# CITY OF ALBUQUERQUE

January 25, 2021

**RE: Ceja Vista Unit 1**  
**Engineer's Certification Date: 12/14/20**  
**Engineer's Stamp Date: 10/04/19**  
**Hydrology File: P09D002F**  
**CPN # 614193, 614194, & 614195**

Based on the Certification received 12/14/20 and site visit on 01/22/20, this certification is **not** approved in support of ROFG/SIA by Hydrology. As noted the Release of Financial Guarantee includes the following Work Order projects: 614193 (Ceja Vista Unit 1 Phase I Off-Site Infrastructure Improvements), 614194 (Valle de Atrisco On-Site Infrastructure), & 614195 (Ceja Vista Unit 1 Phase II Infrastructure Improvements).

CITY PROJECT NO. **614194** ZONE MAP NO. **P-9-Z** SHEET **4.1** OF **15**

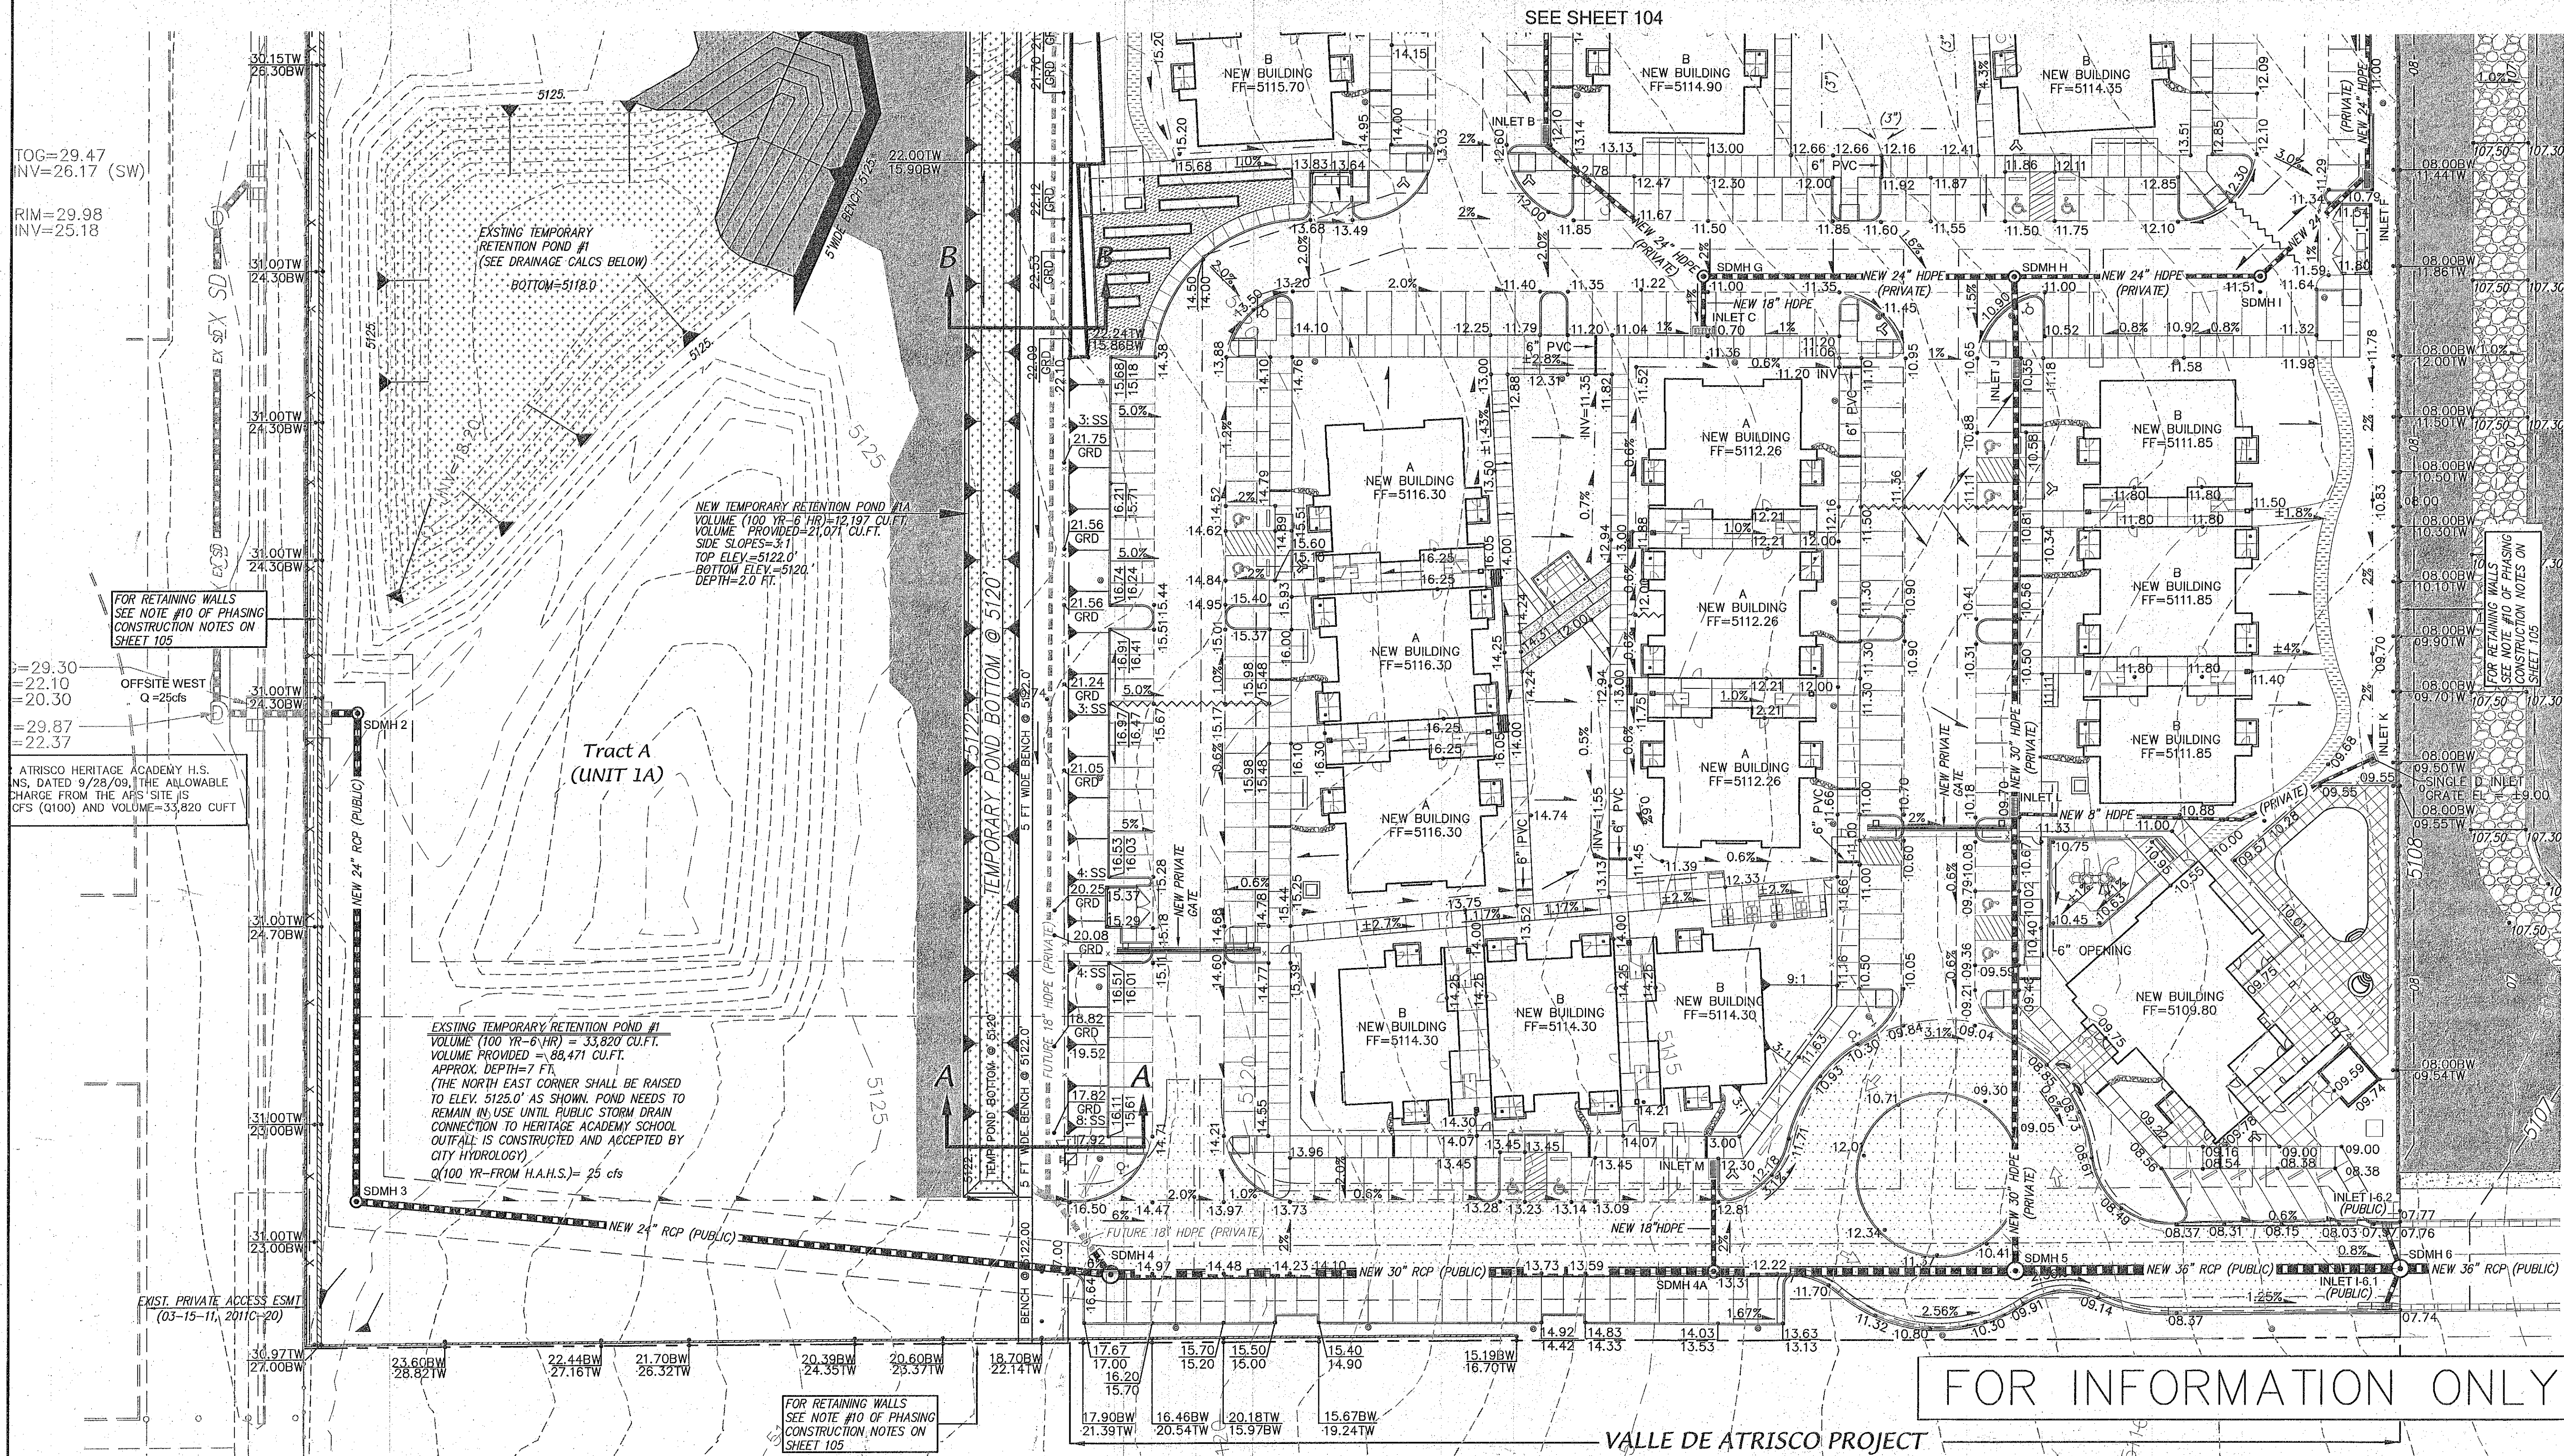
5. As shown on the certified Grading & Drainage Plan, it stated that grades at the entrance of the Apartments will drain to the Type A inlet at the entrance. However, as I was leaving I notice some water that the contractor had used to wash something. But this drainage did not flow as designed or as you had certified. This did pond and drainage across the drive but it still did not flow the Type A inlet on the other side. It appears that both Type A inlets were installed as a waterblock to the site so this drainage will have to be addressed in the Work Order. See Photos Below.

POND DETAIL SECTION A-A
SCALE: 1"=10'

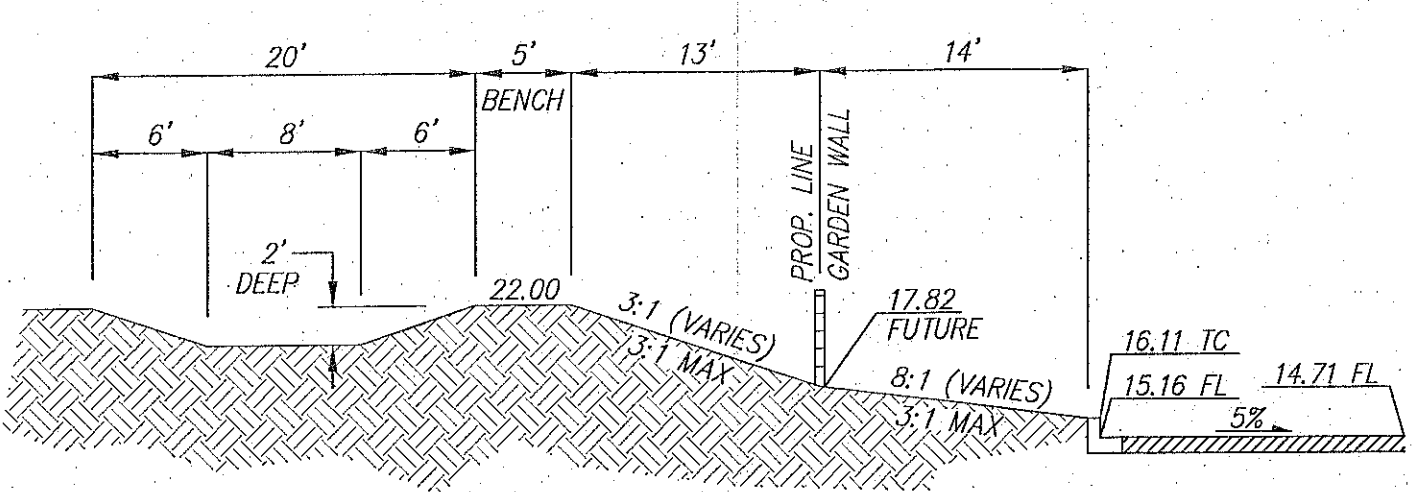
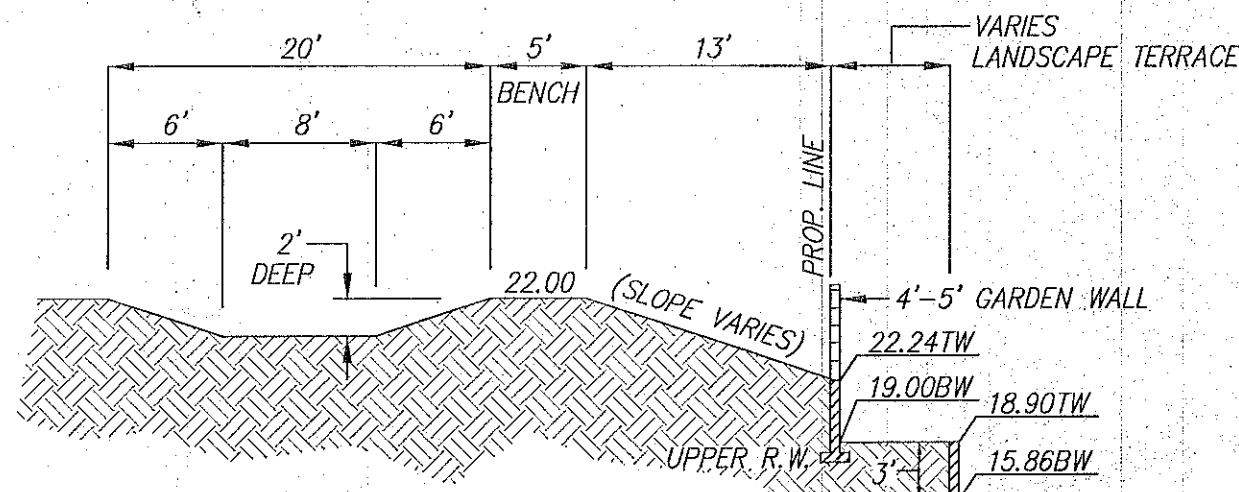
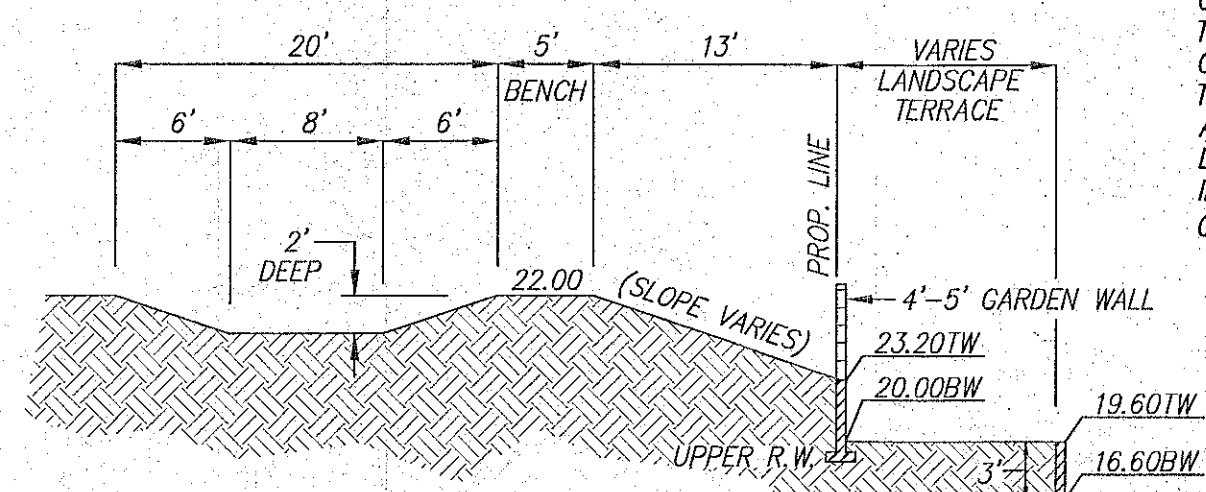
4. It also appears that the pond was not built per the construction plans. There was not berm built around the pond, the emergency spillway does not appear to be built, and section A-

A along the west side of the channel and pond was not built. It does not seem that the pond was actually as-built surveyed. Please include all as-built grading in this certification.

CITY PROJECT NO.	ZONE MAP NO.	SHEET	OF
614193	P-9-Z	3.2	20

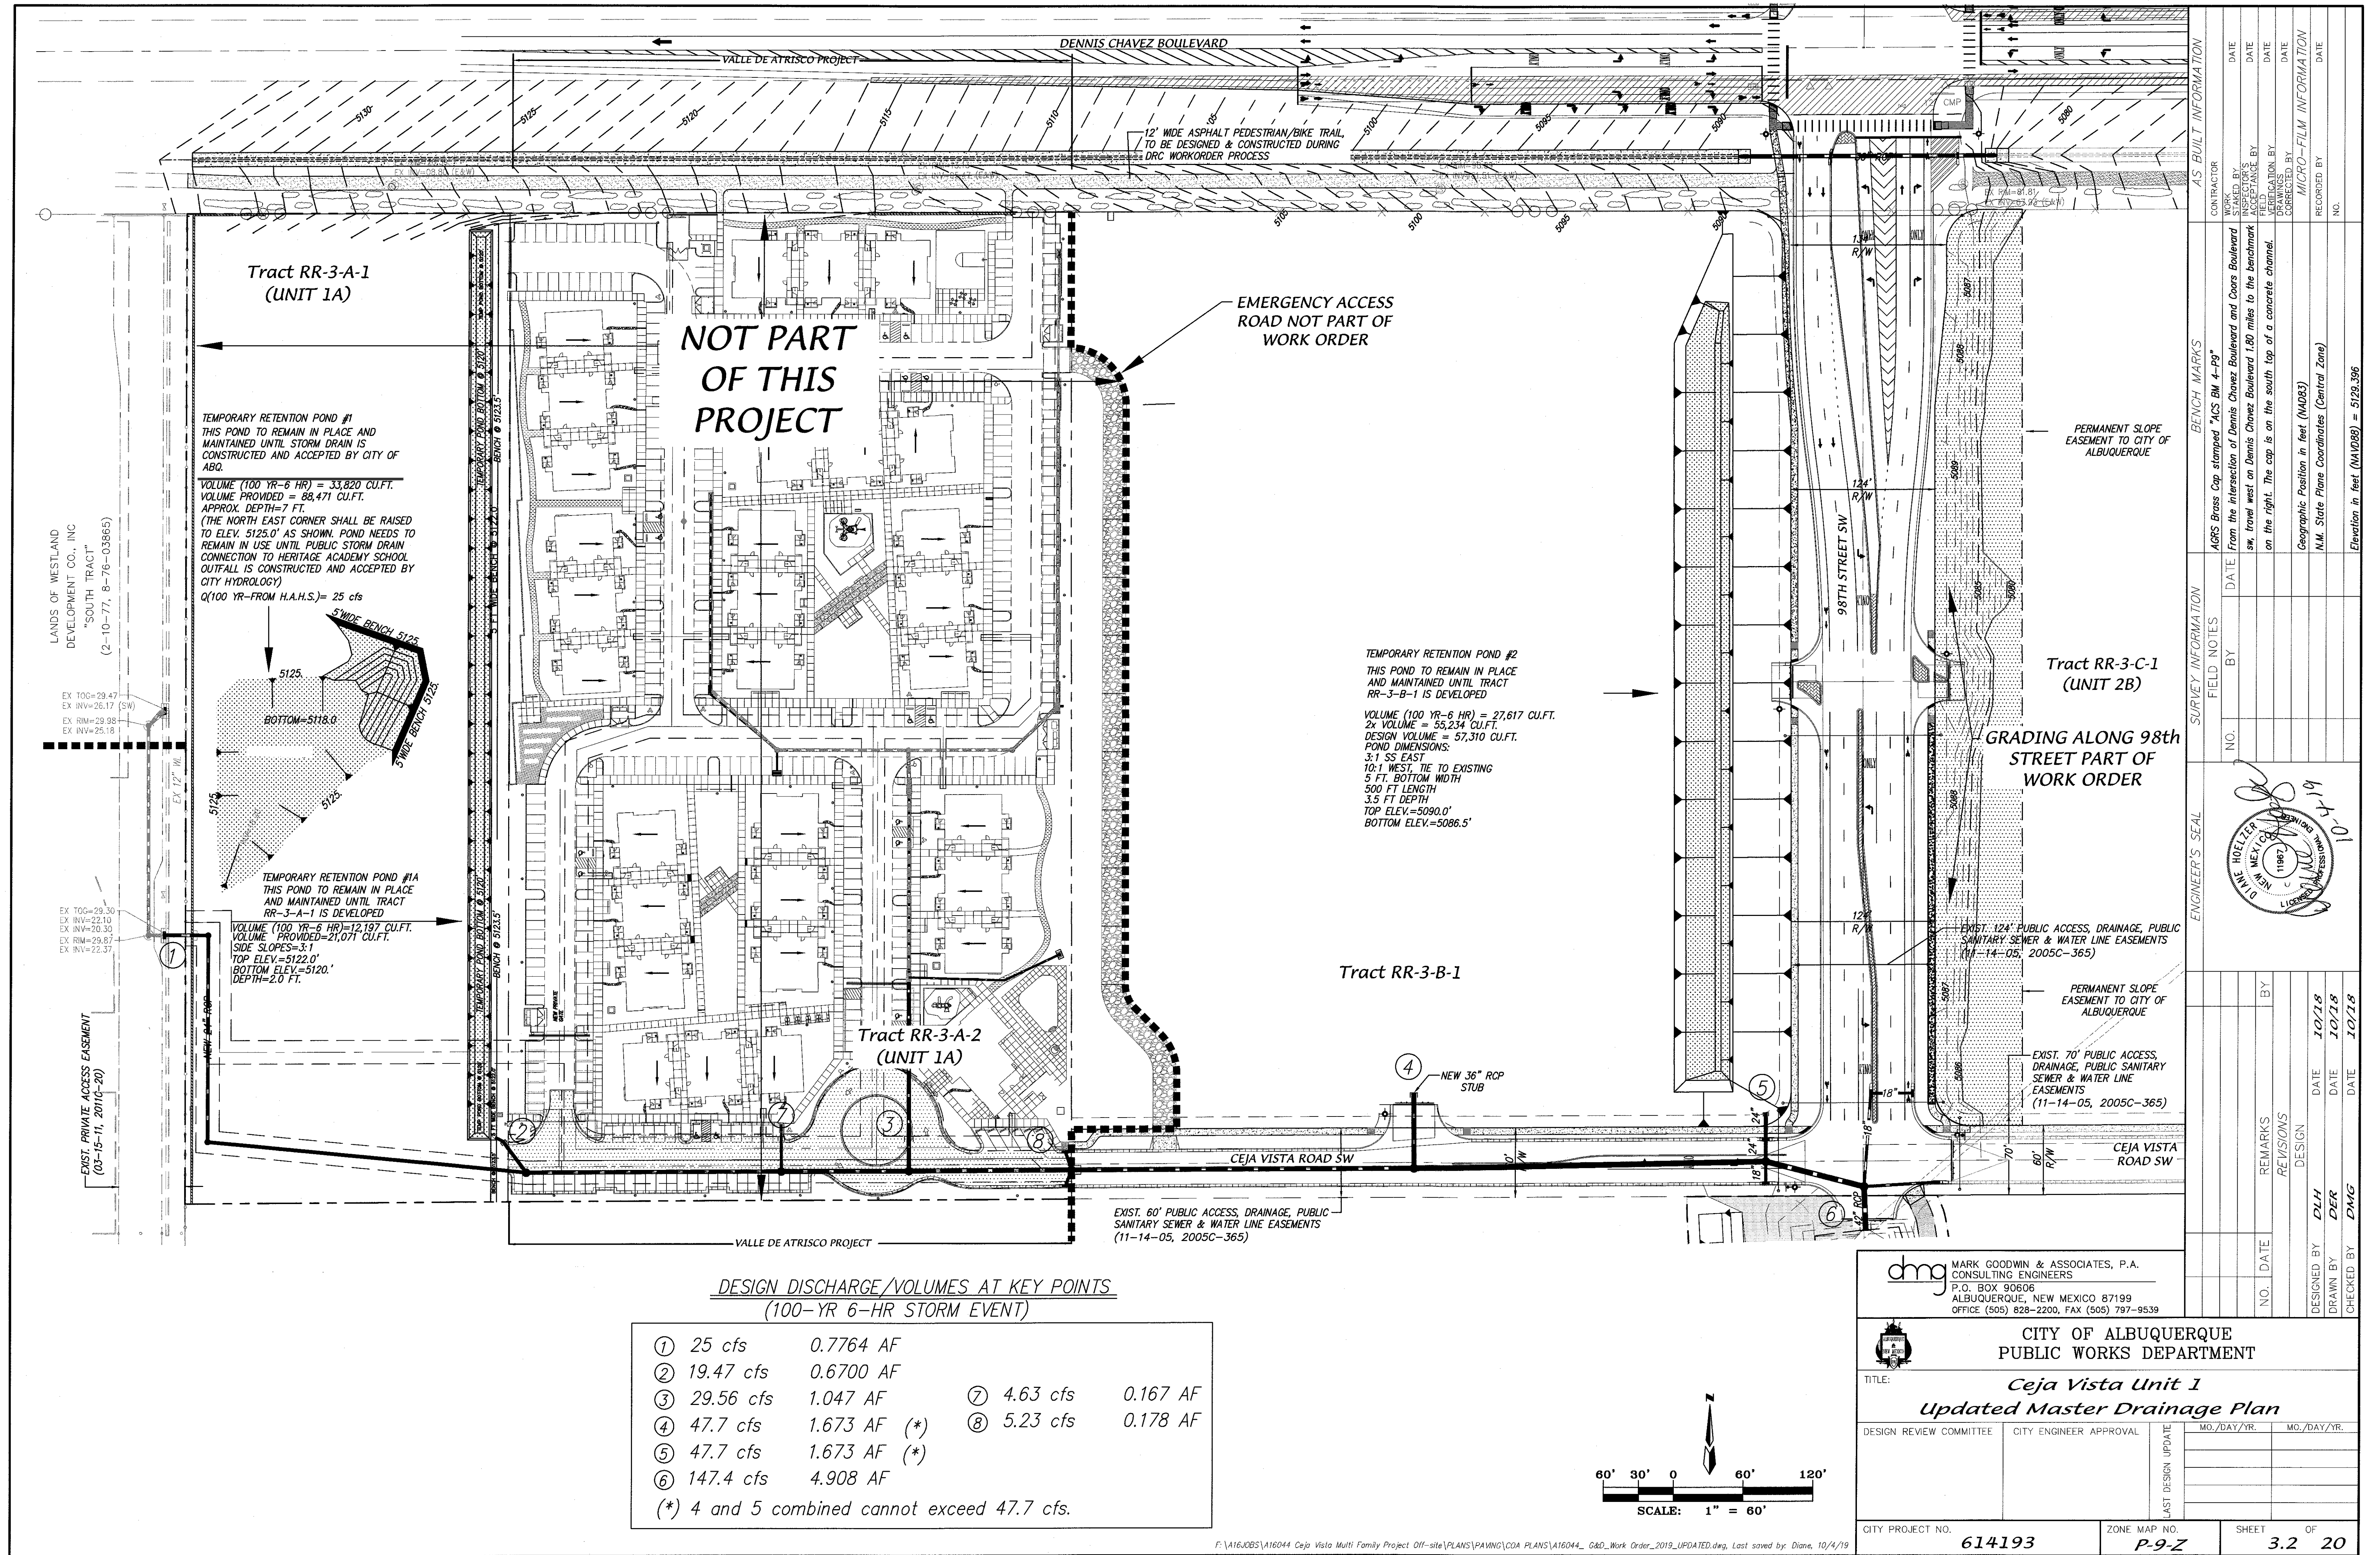
3. Please correct the earth side slopes of the channel. The max design slope was to be 10:1 but it appears that this is steeper and the slope is unstable and is eroding into the concrete channel. Also, please include the as-built grading done along the concrete channel and access road in this certification.
